From: Ian Stocks [REDACTED] **On Behalf Of** FRS Water and Access
Sent: 09 December 2021 08:50
To: Planning.Responses <Planning.Responses@arun.gov.uk>
Subject: Planning consultation - CM/69/21/PL Land at Northwood Farm Yapton Road BN18 0HR

Having viewed the plans for planning application CM/69/21/PL, the nearest fire hydrant to the proposed Flexible Generator Plant and associated infrastructure is 515 metres away, 425 metres more than the required 90 metres distance for a commercial property. Although this is not more than 280m2 compartment size there is no supply of water for firefighting. If an alternative supply of water for firefighting is considered it will need to conform with the details identified in Approved Document – B (AD-B) Volume 2 2019 edition: B5 section 16.

Drawing Title:
PROPOSED SITE PLAN

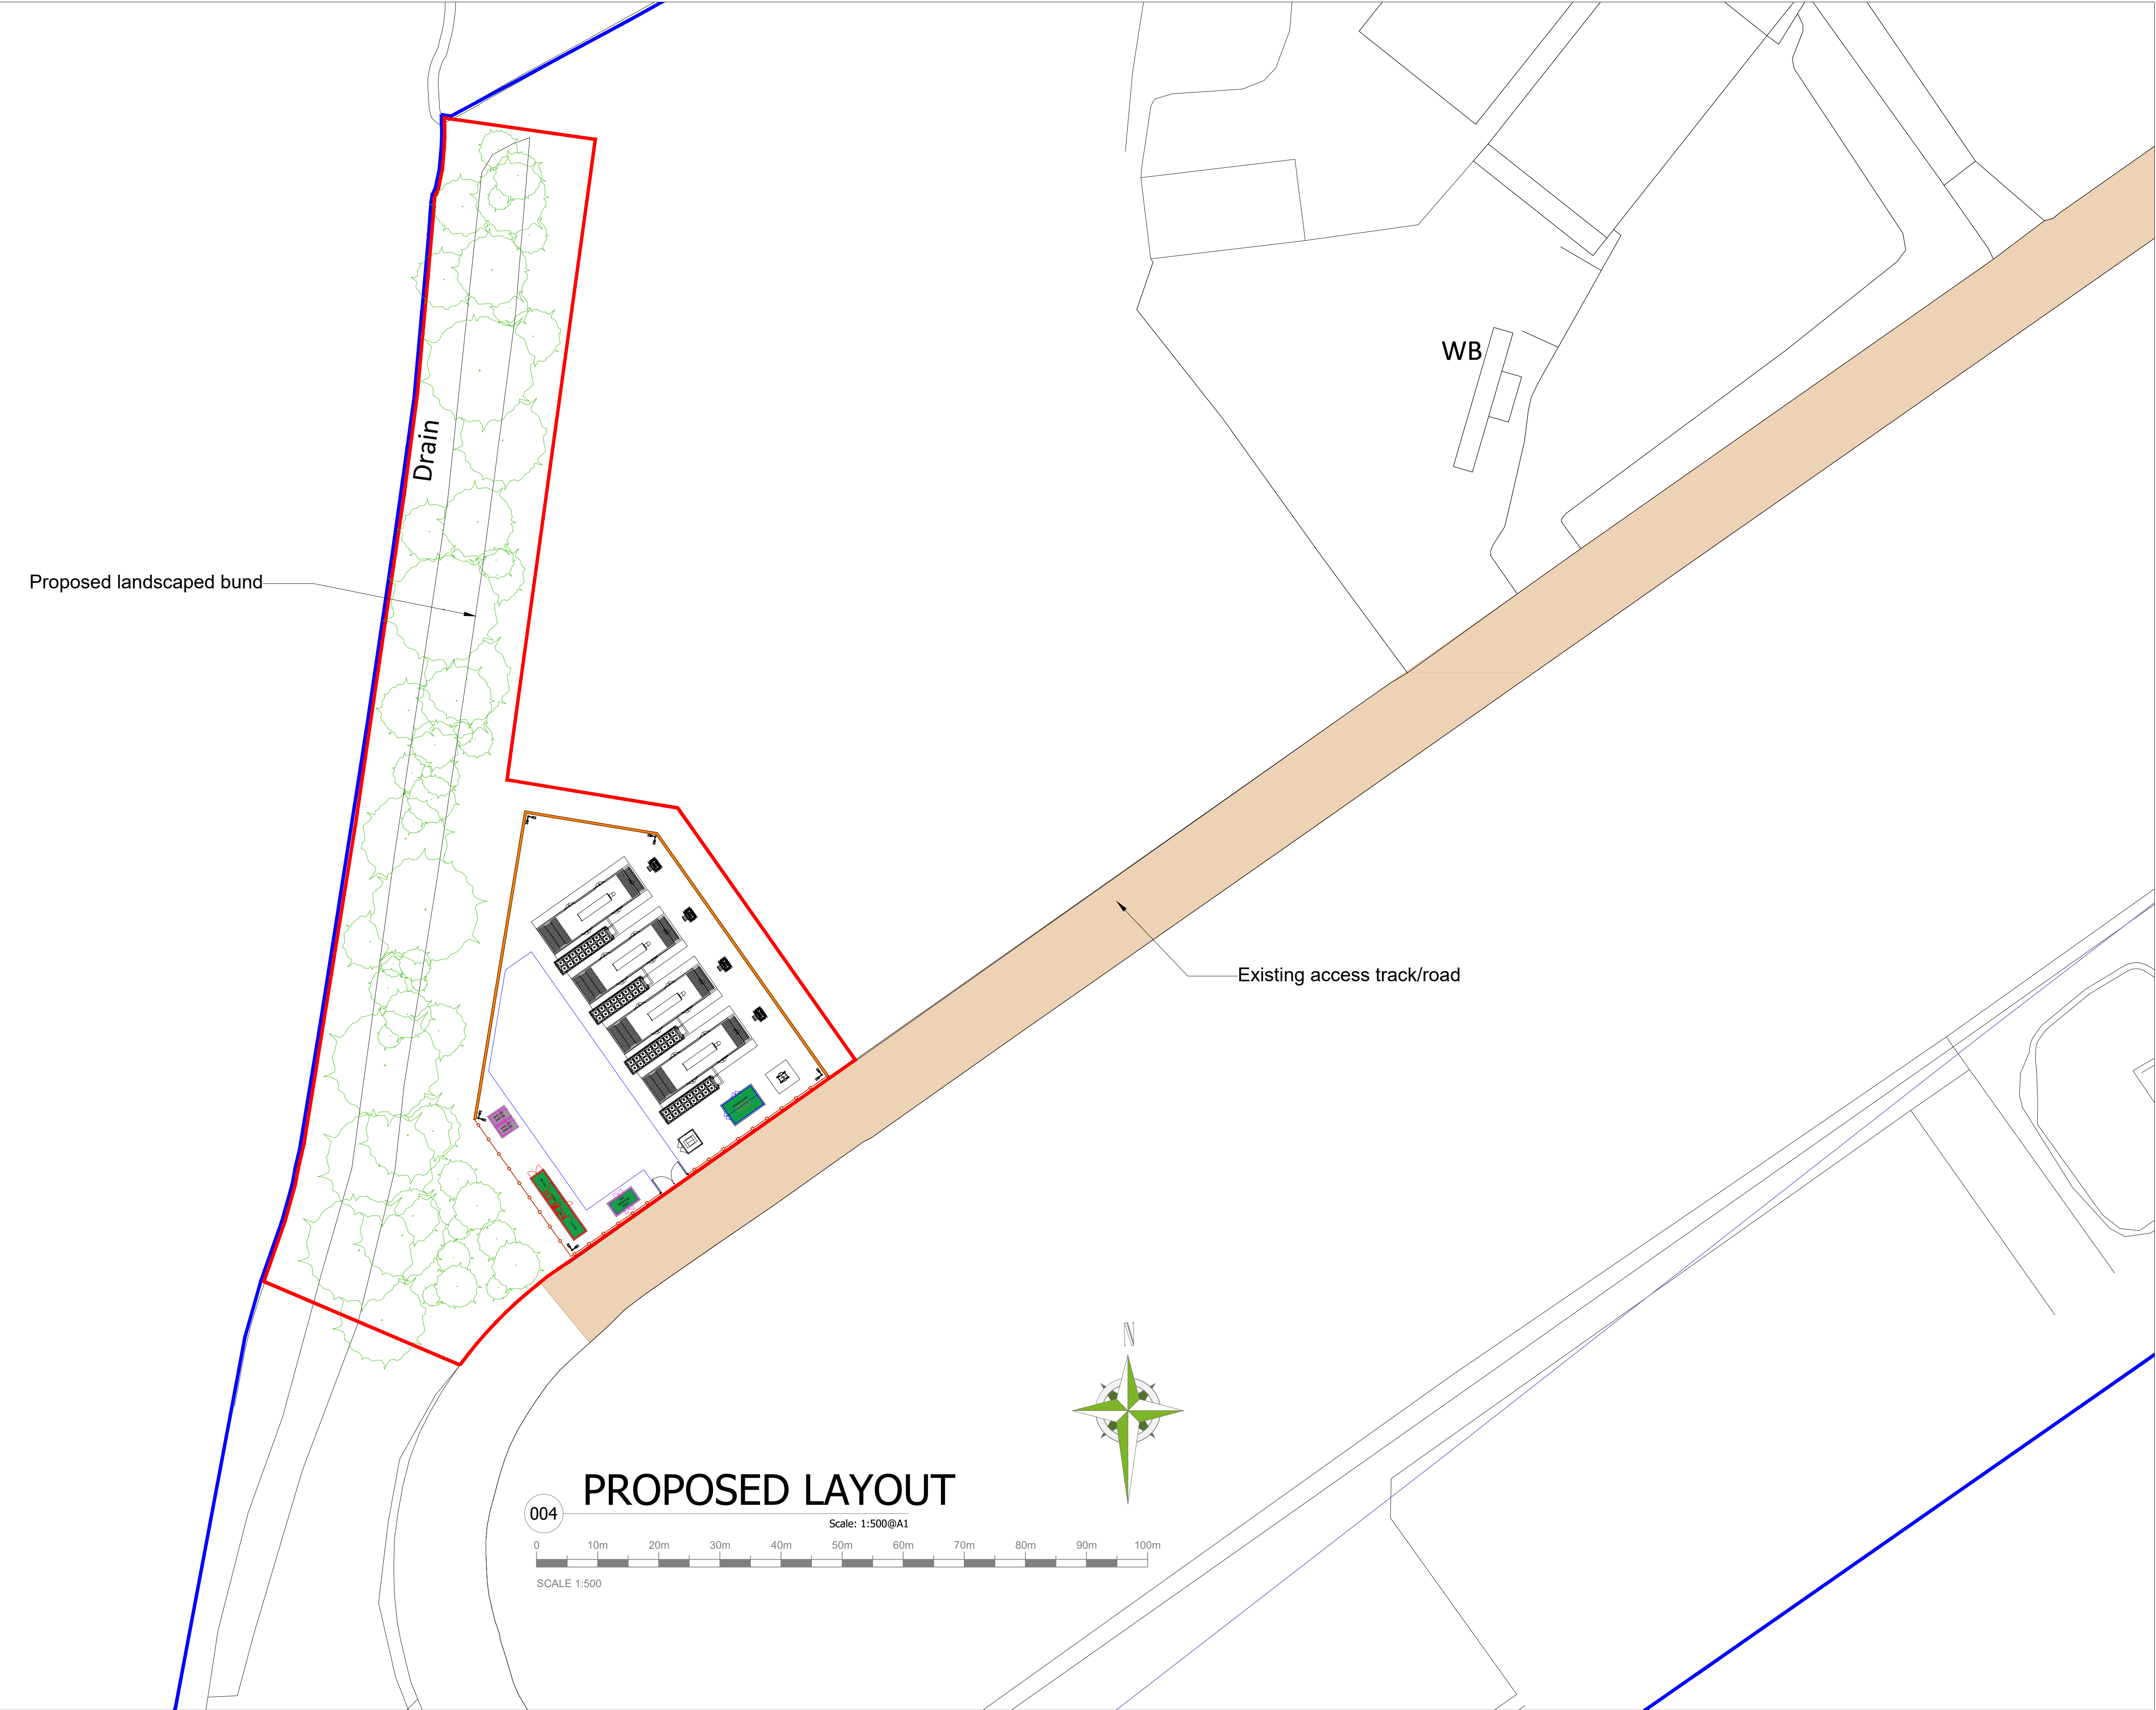
Evidence will also be required that Fire Service vehicle access meets with the requirements identified in Approved Document B Volume 2 2019 Edition: B5 Section 15, including Table 15.2 and diagram 15.3.
